Rezoning Transportation Analysis
Petition Number: Insert Zoning Petition #2021-206
General Location Identifier: 04729144

Revision Log:

Date	Description
01-27-22	First Review (TM)
02-24-22	Second Review (TM)

REZONING PETITION 2021-206
 RZ-2 : TECHNICAL DATA SHEET

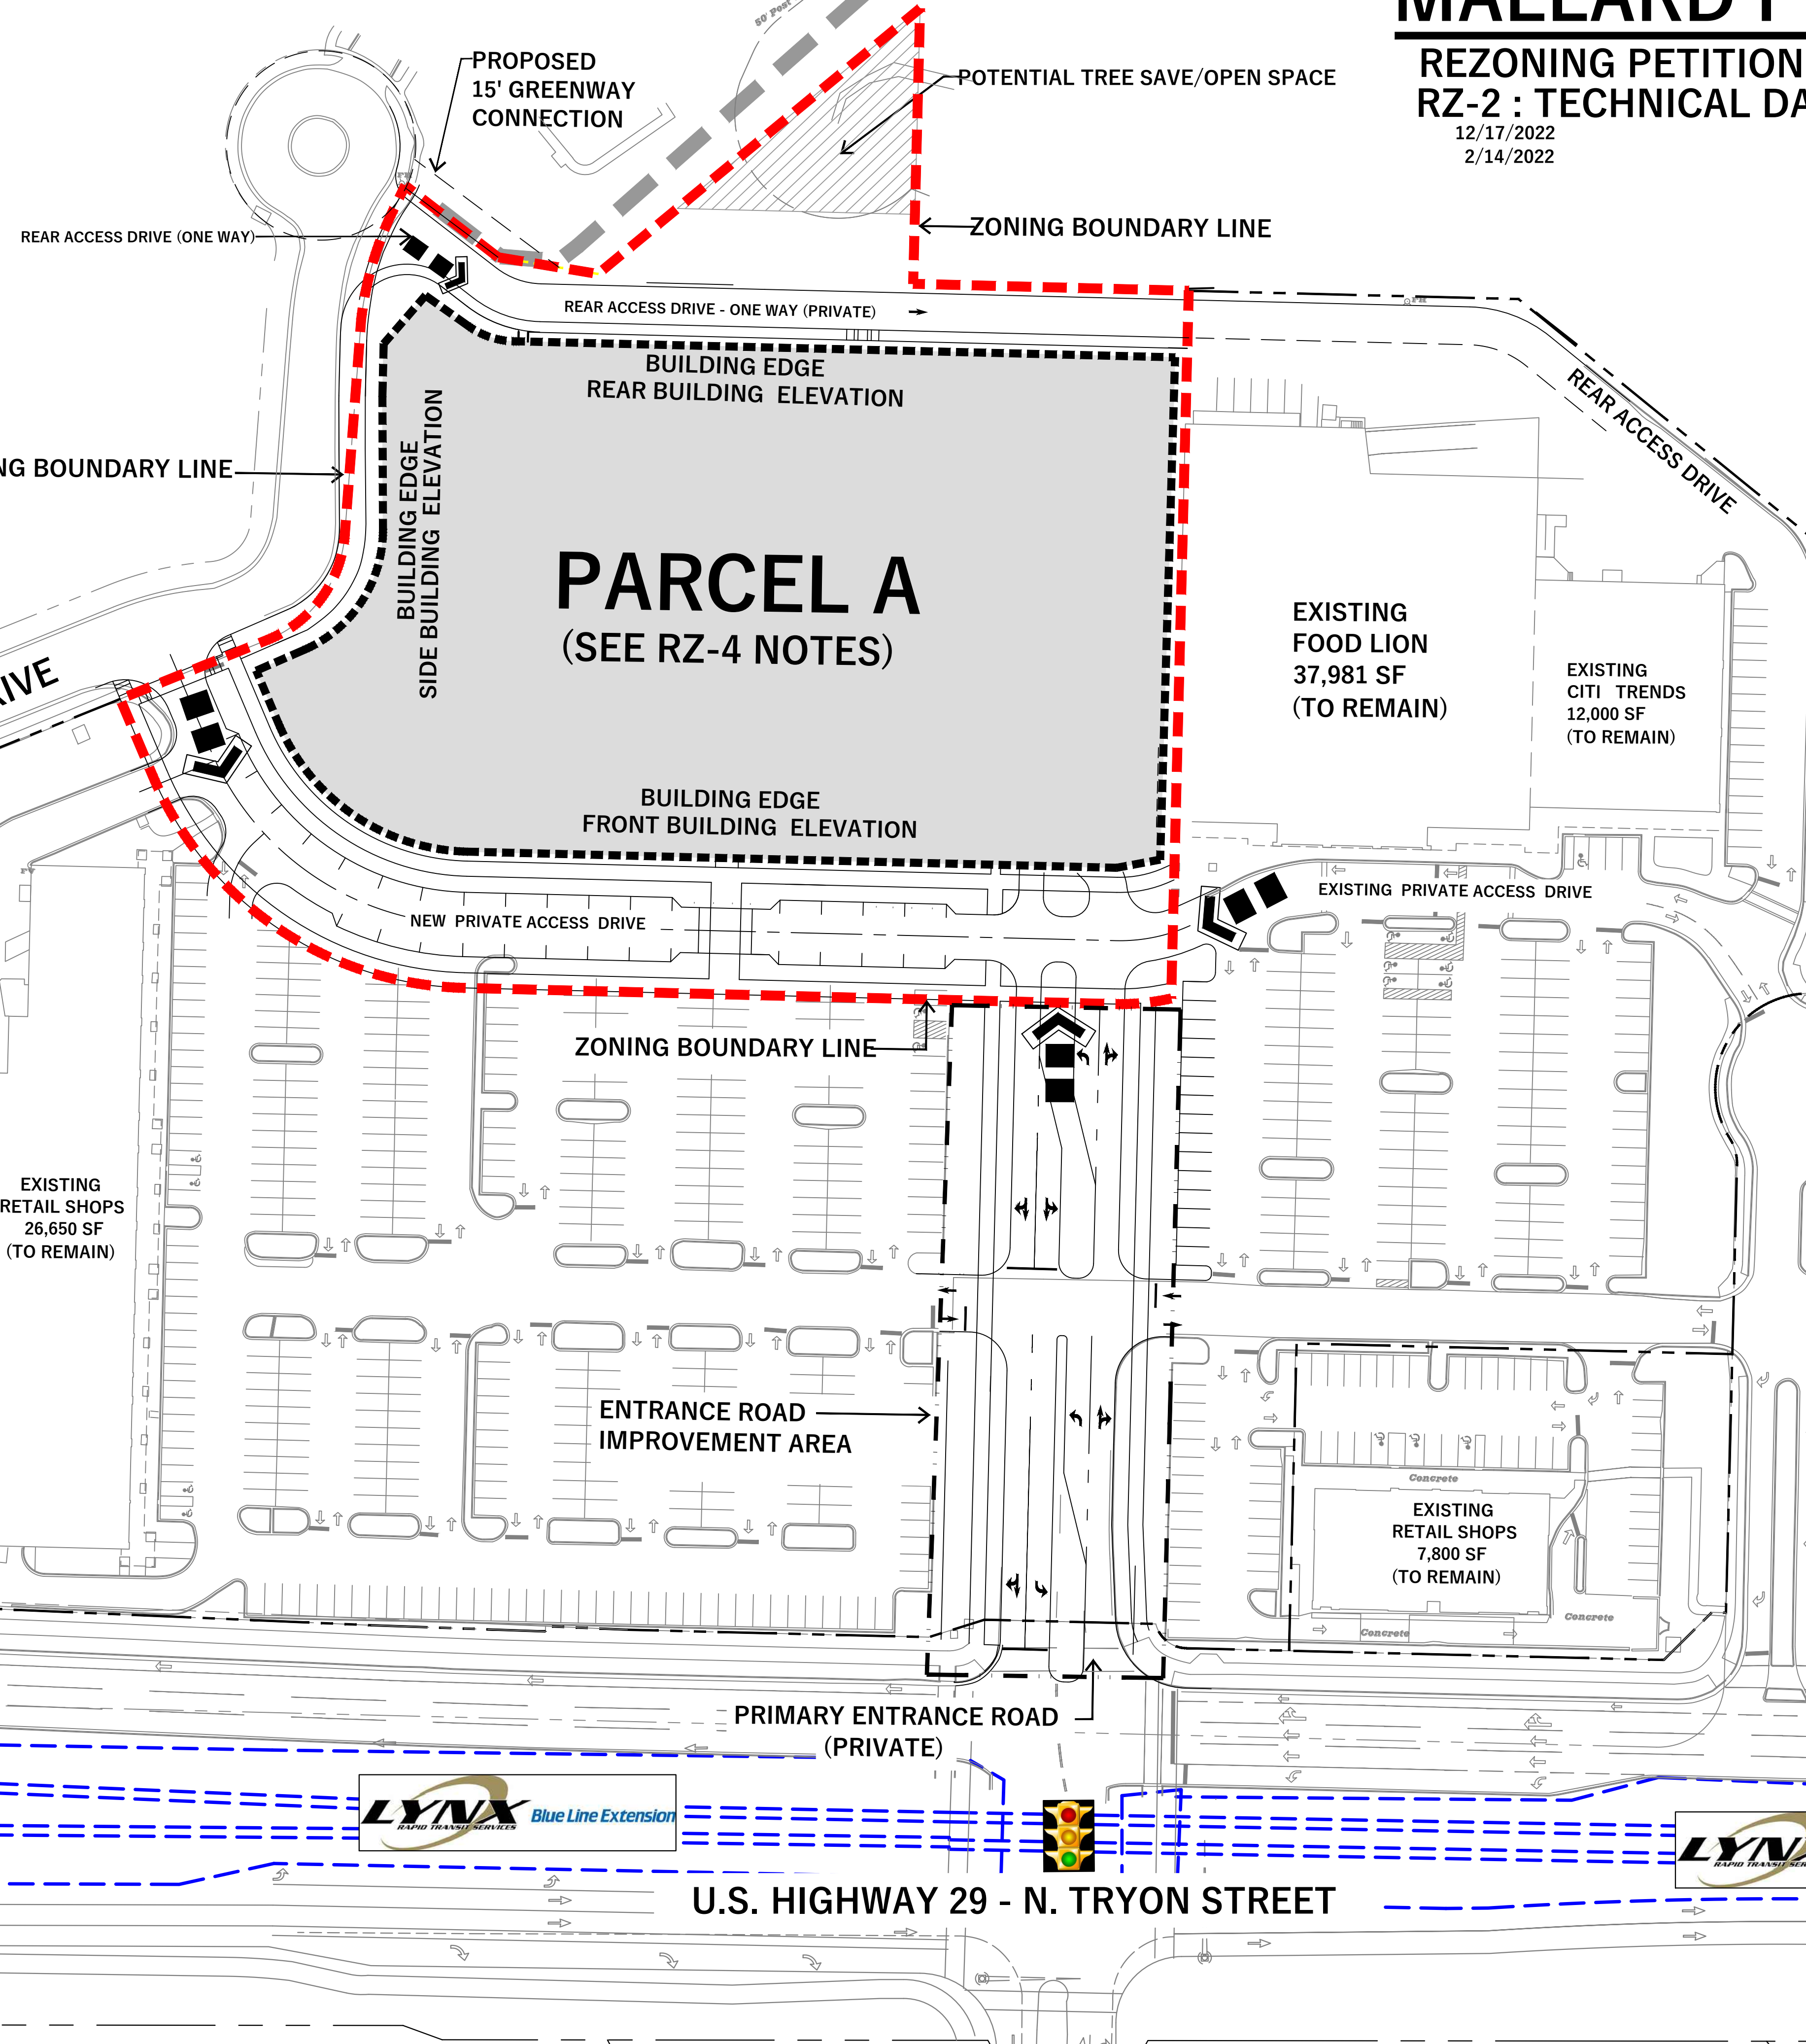
Label and dimension the curb and gutter from the centerline for each road on the site plan.

Outstanding Comment from 01.27.2022: Dimension curb and gutter along Olmsted Drive from centerline of roadway.

3. Label and dimension the existing or proposed planting strip and sidewalk along the property frontage of Olmsted Drive to provide clarity. In addition revise site plan and conditional notes to commit to installing curb ramps at the driveway connections or reconstruct the driveways as Type II Modified per CLDSM 10.25E.

Clarifying Comment from 02.24.2022: Dimension planting strip and sidewalk along Olmsted Drive to provide clarity.

4. The proposed dwelling units exceeds 12 per acre. Per Chapter 20 Subdivision ordinance, site plan and conditional note(s) revisions are needed to commit to construct an 8-foot planting strip, and 8-foot sidewalk along Olmsted Drive. The wider sidewalk also meets the Charlotte WALKS Policy. In lieu of constructing the wider sidewalk at the property frontage, CDOT is requesting sidewalk is installed to connect the existing sidewalk on the frontage of the petition to the sidewalk at the corner of the Olmsted Drive and J W Clay Boulevard intersection. An 8-foot planting strip and 8-foot sidewalk is preferred.

Clarifying Comment from 02.24.2022: CDOT is requesting sidewalk is installed along Olmsted Drive from the frontage of petition to the intersection of J W Clay Boulevard intersection.

5. ~~Label the proposed streets as private to provide clarity to the site plan. Add conditional note stating the roads are to be private.~~
6. ~~Label and dimension the limits of the proposed public access easement on the private streets.~~
7. Label and dimension the sidewalk and planting strip widths on the proposed private streets. Dimension the back of curb from the centerline of the roadways.

Clarifying Comment from 02.24.2022: Dimension the back of curb from the centerline of the roadways.
